9 March 2009

**Re: Site 3, Australia Avenue, Sydney Olympic Park – MAJOR PROJECT No. 06_0127
Section 75W amendments**

— EXTENT OF ENVIRONMENTAL ASSESSMENT SHADOWS
■ SECTION 75W SHADOWS

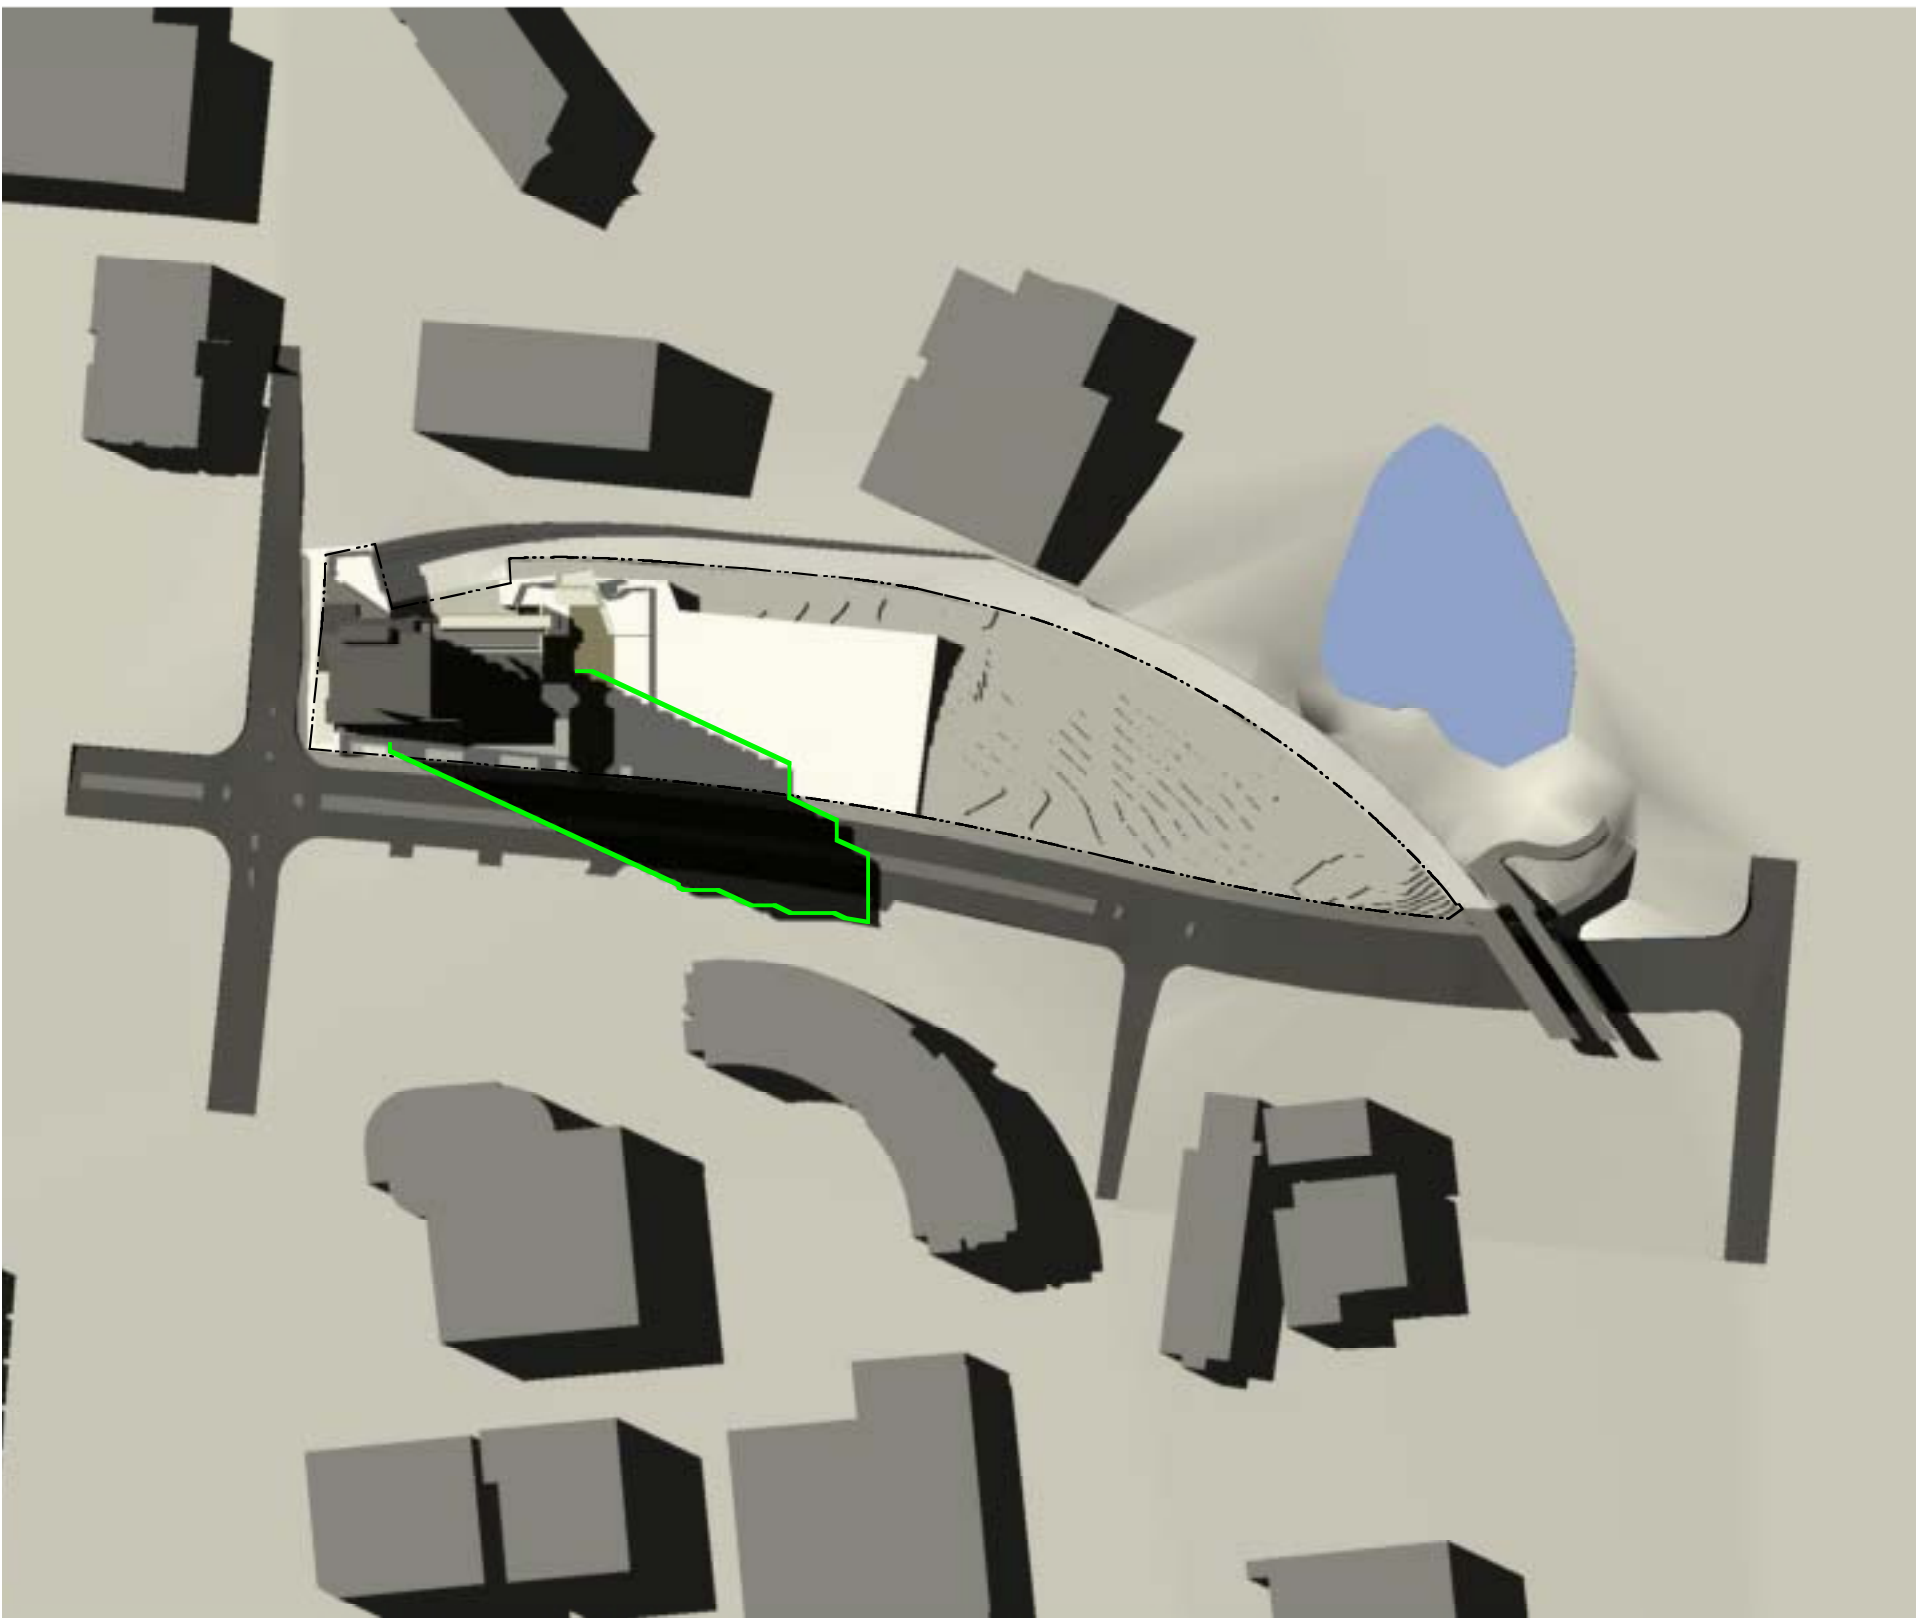
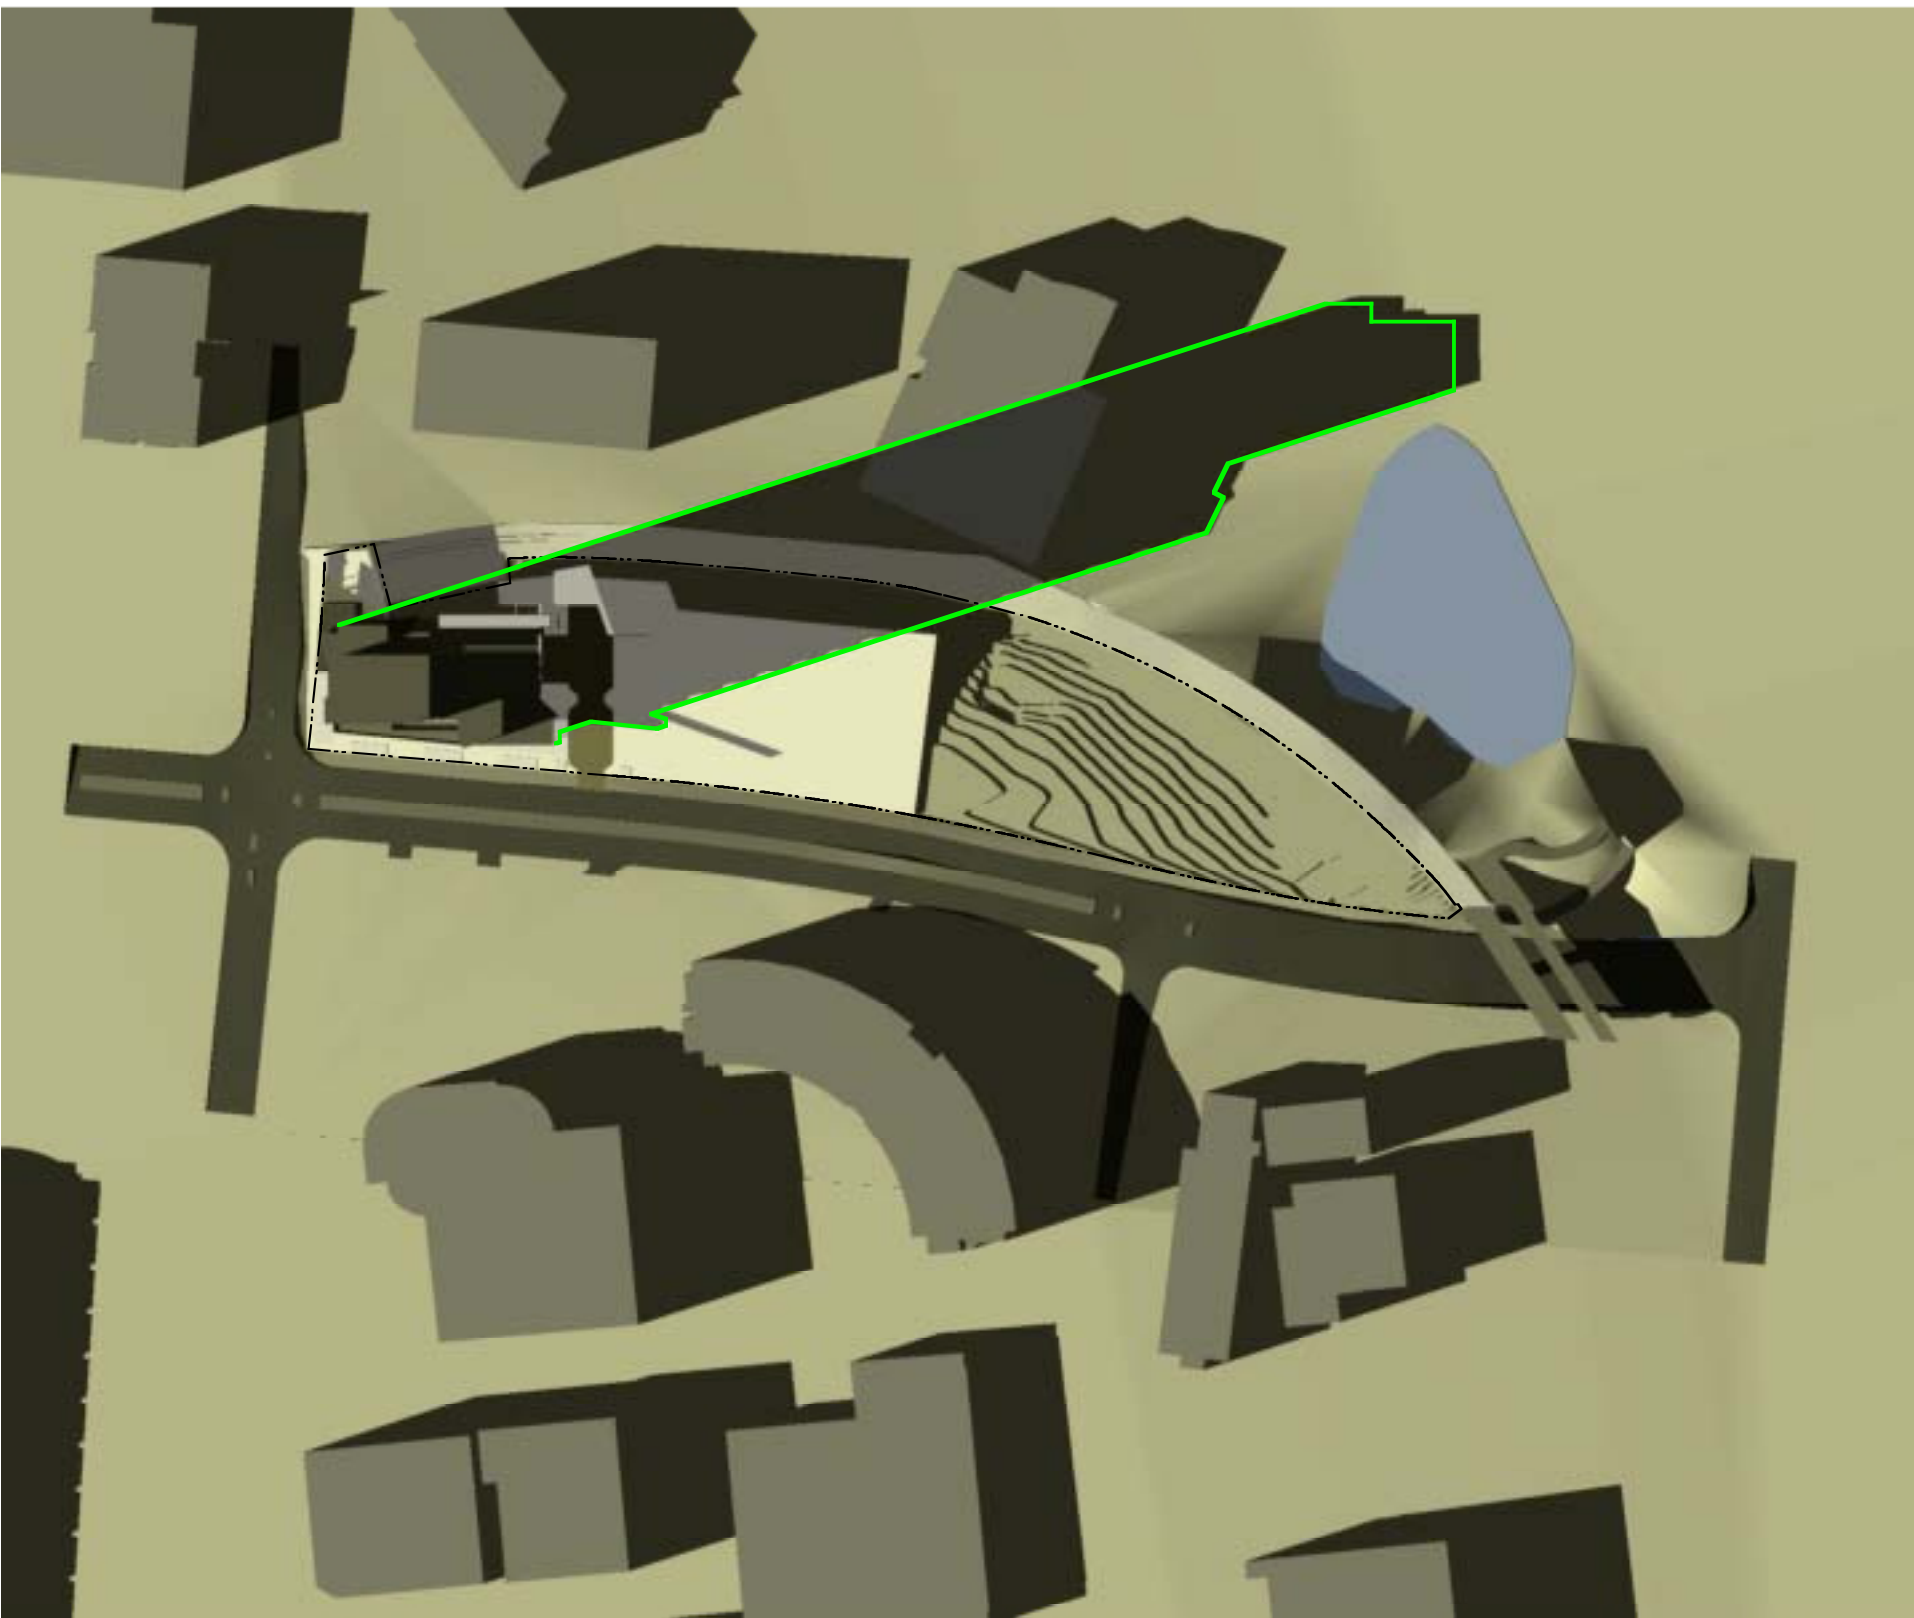
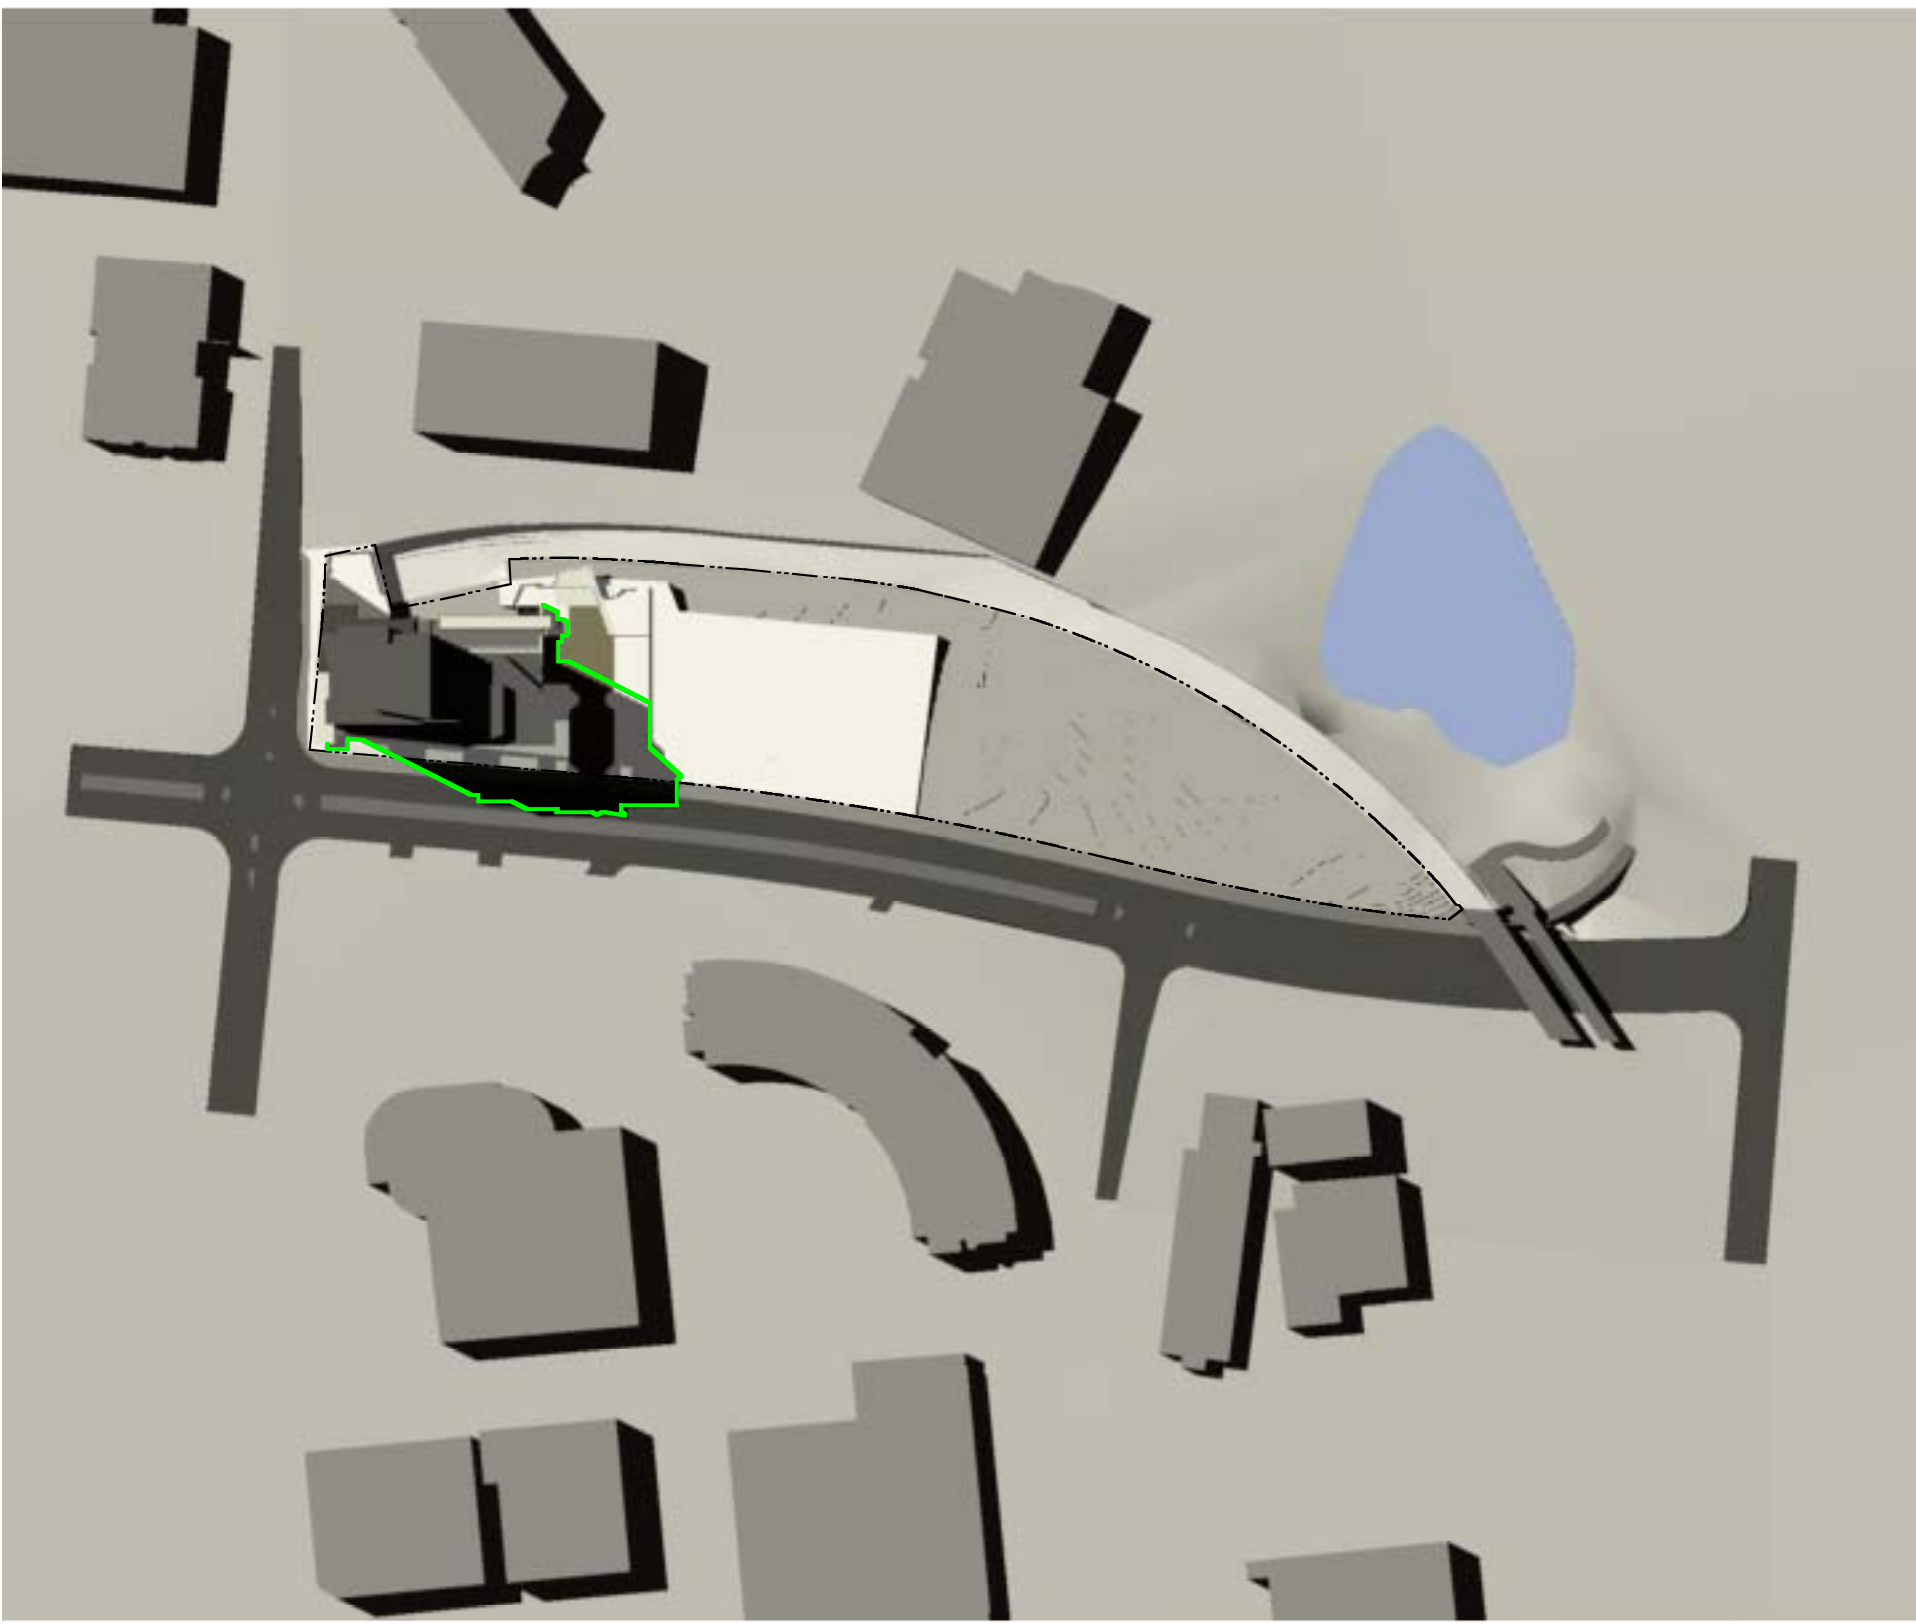
Overall this equates to Tower A part of the building being 2.6 m higher and Tower B part 1.7 m higher. In relation to the original approximate building heights of 80.65 m (A) and 55.6 m (B) the increase is minor and does not cause any significant loss of amenity to its surroundings. On 22 June the shadow of Tower A would increase by only 4.1 m at 12pm and 7.8 m longer at 9am/ 3pm. Tower B's shadow would increase by only 2.7 m at 12pm and 5.1 m at 9am/ 3pm on the same date.
